Scholz Extended Family Housing, AL-17-025

Please accept the following comments from El Paso County Public Health in support of the special use project referenced above:

SCHOLZ/BOERTS

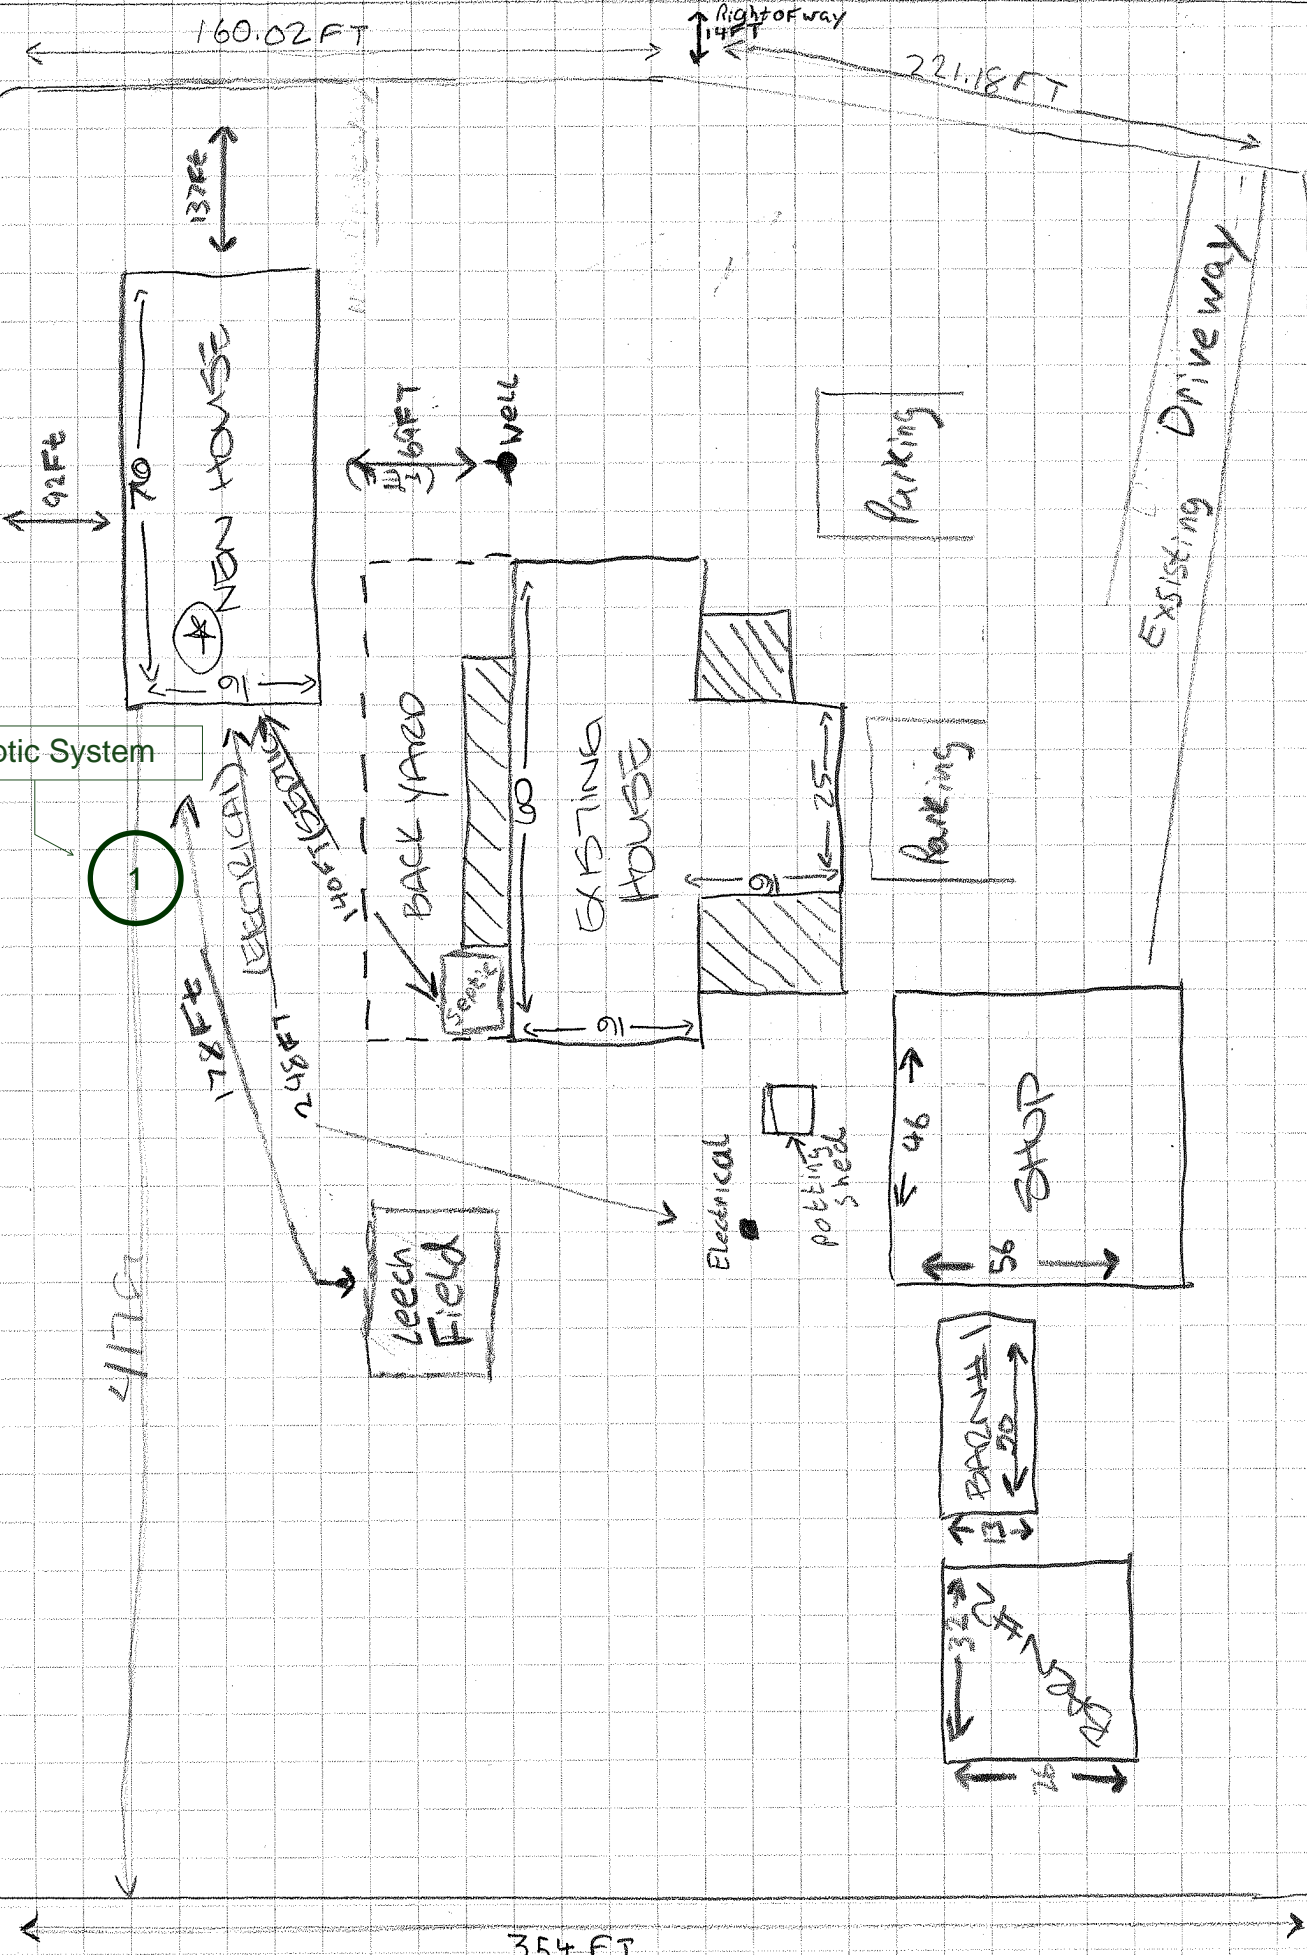
- **Water service for the existing home and the proposed temporary second house is by an existing individual well.**
- **Wastewater service for the project is provided by an existing onsite wastewater treatment system (OWTS) that was installed in 1985 and sized and approved for the existing 2 bedroom house. The proposed second house is planned to be serviced by a new OWTS. The new OWTS must be approved and permitted by El Paso County Public Health.**
- **There appears to be sufficient area for the proposed second dwelling and the new OWTS.**
